# LOT 3, PADMARK BUSINESS PARK FIL. NO. 1

EL PASO COUNTY, STATE OF COLORADO  
GRADING & EROSION CONTROL PLAN

GRADING & EROSION CONTROL PLAN  
LOT 3, PADMARK BUSINESS PARK FIL. NO. 1  
JOB NO. 44-031  
DATE PREPARED: JUNE 29, 2018  
DATE REVISED:

EL PASO COUNTY FILE NO. PPR 18-000

GRADING & EROSION CONTROL PLAN
LOT 3, PADMARK BUSINESS PARK FIL. NO. 1
JOB NO. 44-031
DATE PREPARED: JUNE 29, 2018
DATE REVISED:

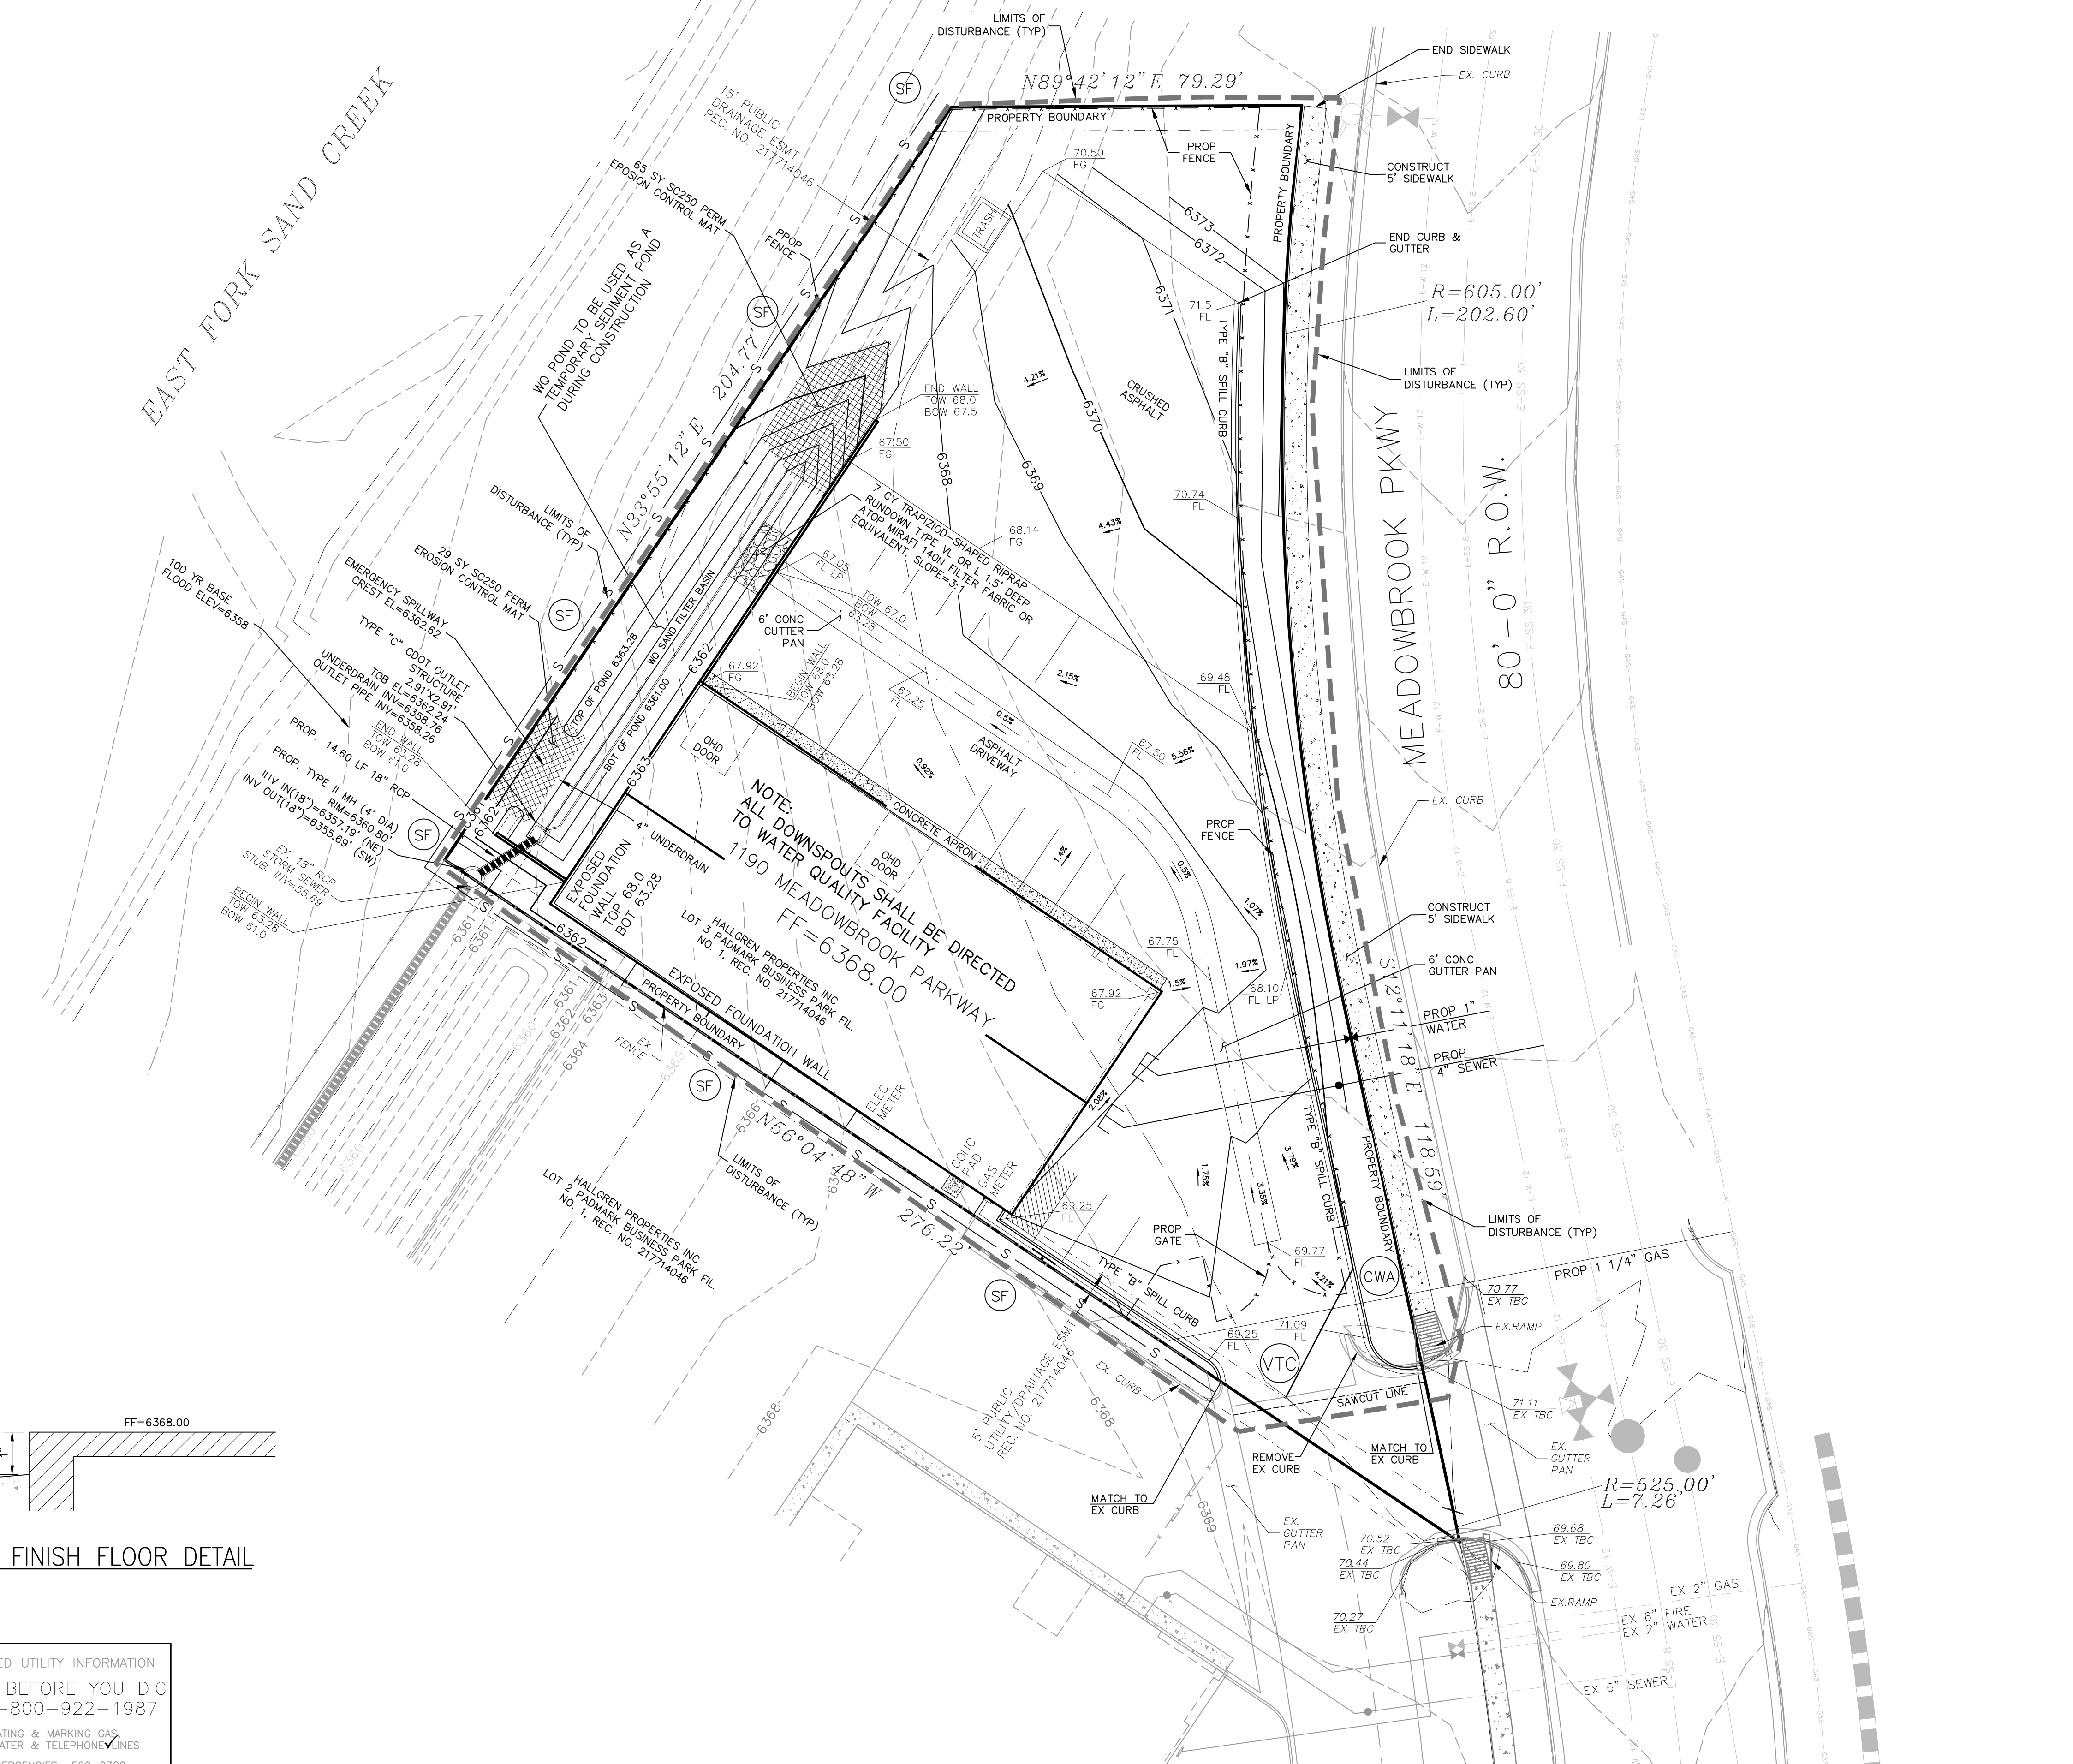
FYI: Obtain permission from the adjacent property owner for construction disturbance and temporary BMPs placed within their property.

Per ADA, handicap parking stall shall not exceed 2%.

GRADING & EROSION CONTROL PLAN DETAILS
 LOT 3, PADMARK BUSINESS PARK FIL. NO. 1
 JOB NO. 44-031
 DATE PREPARED: JUNE 29, 2018
 DATE REVISED:

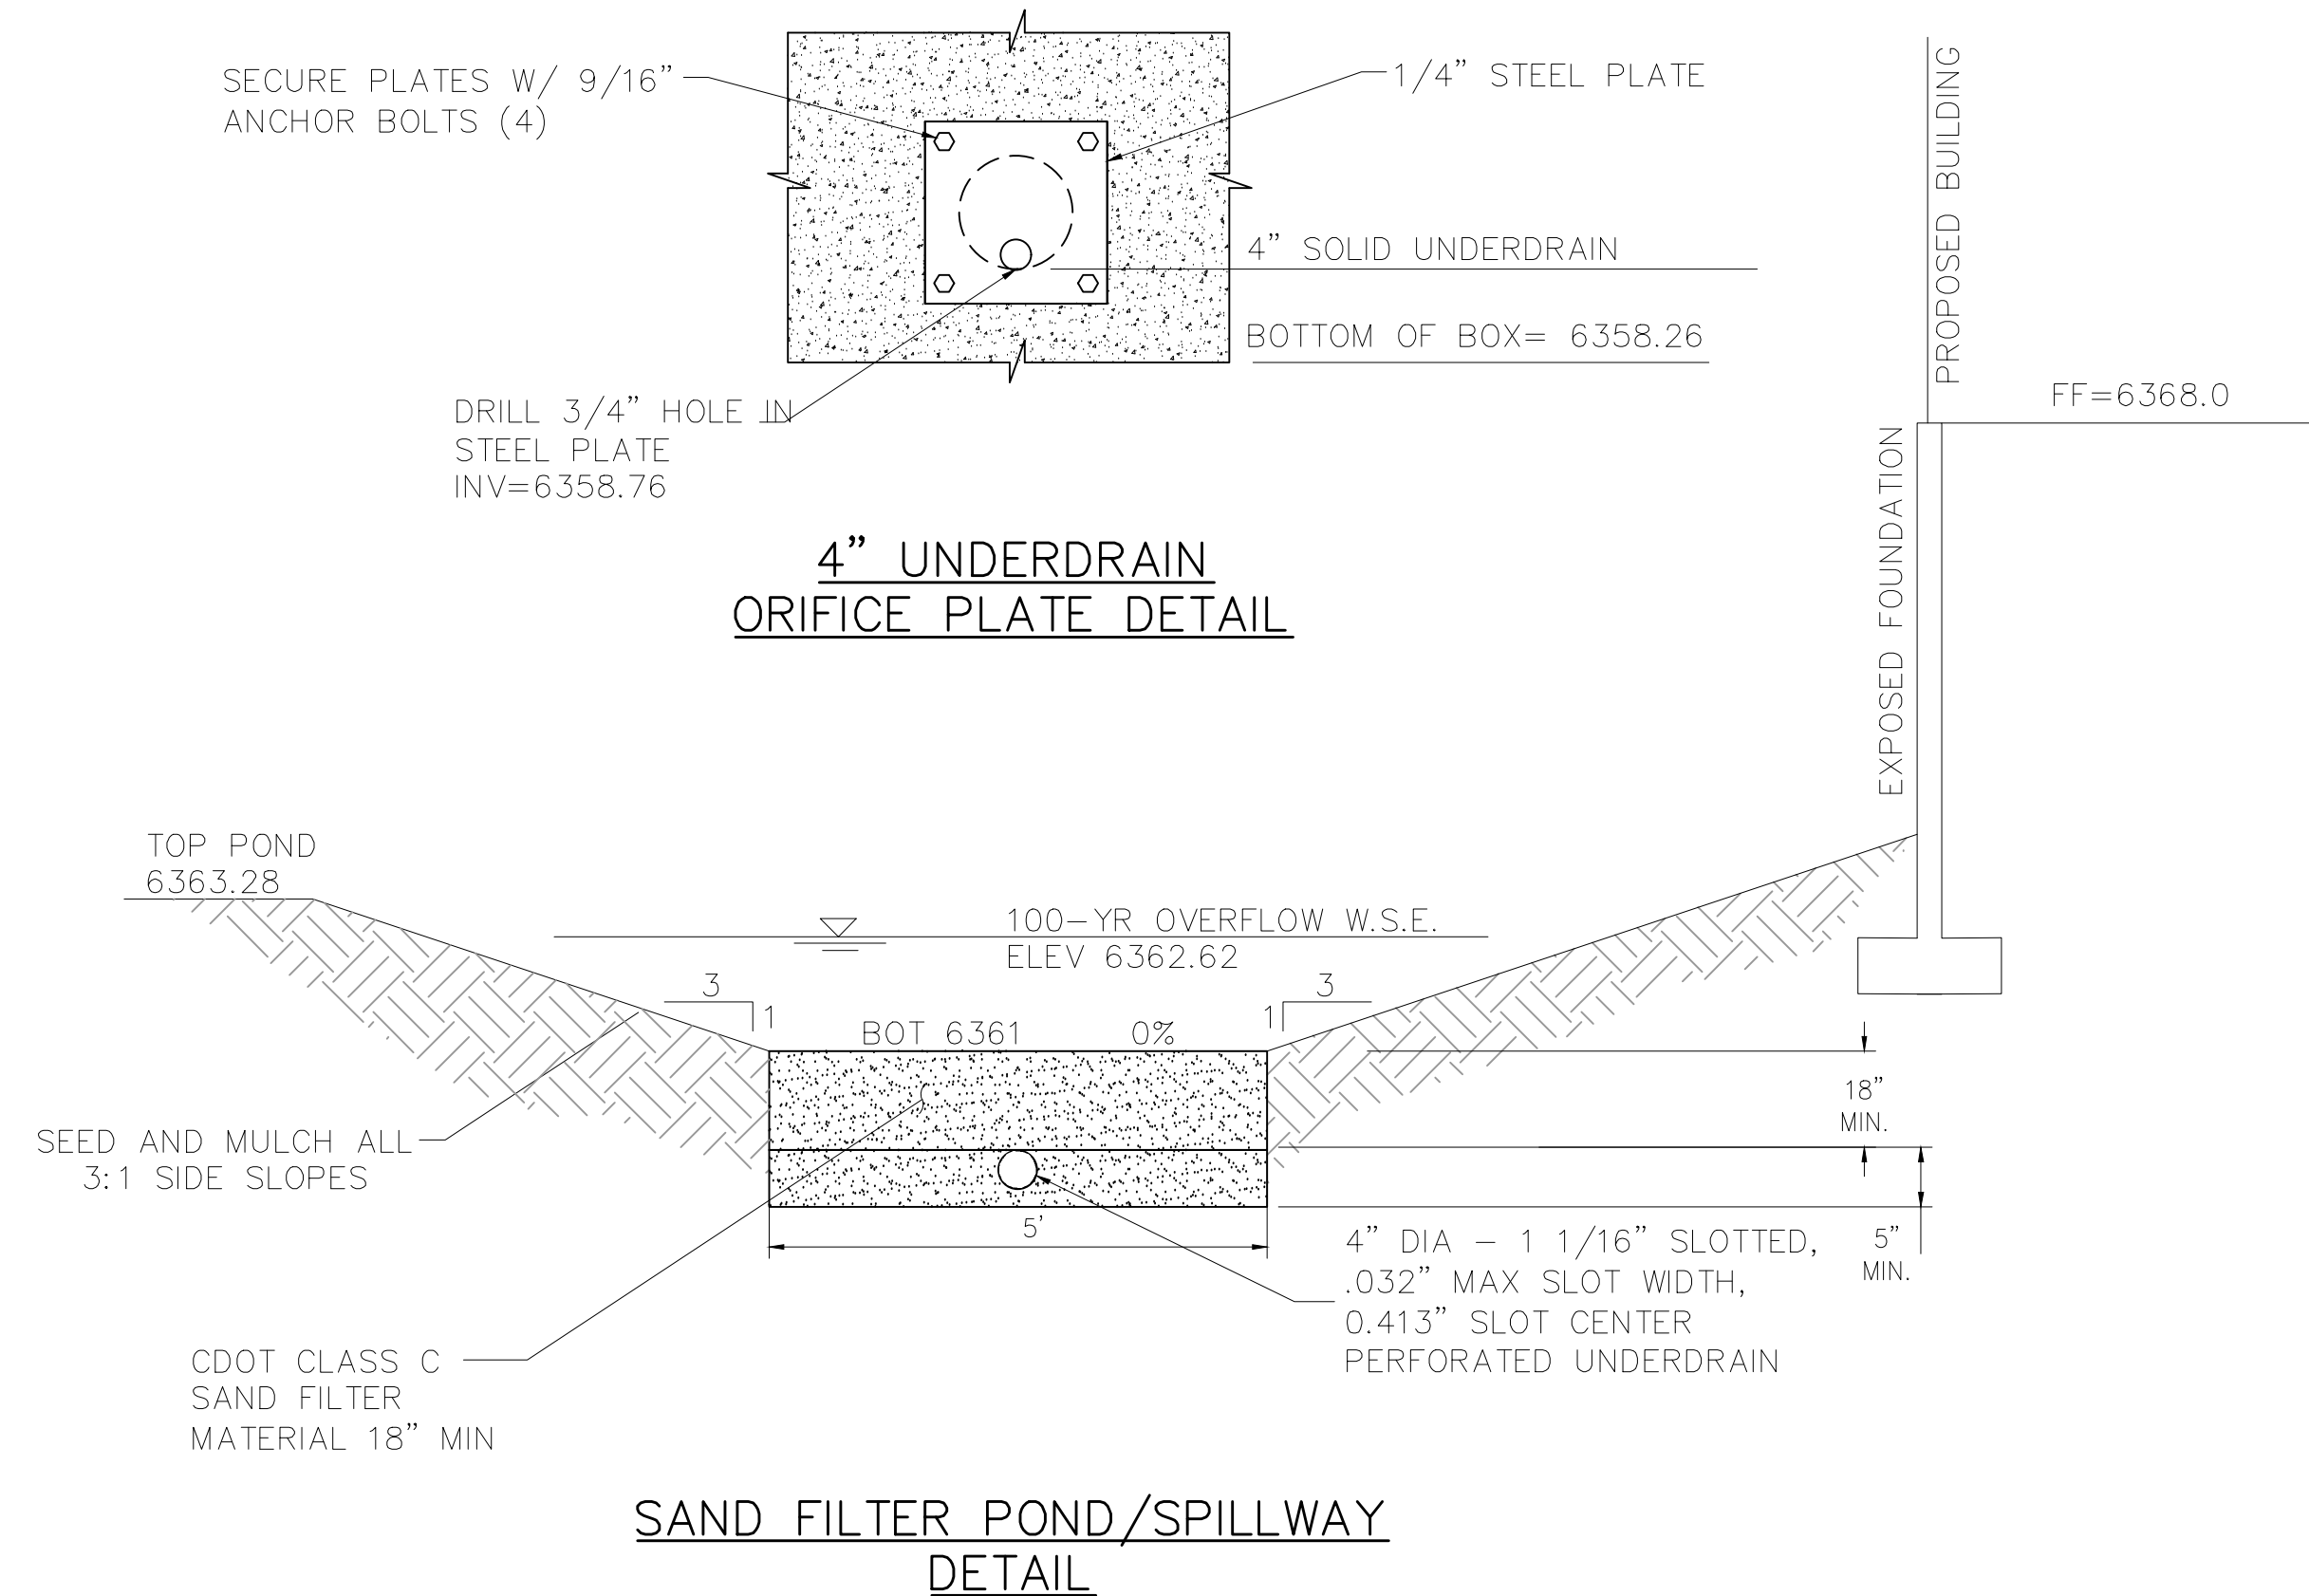
Identify the spillway crest length and side slopes.
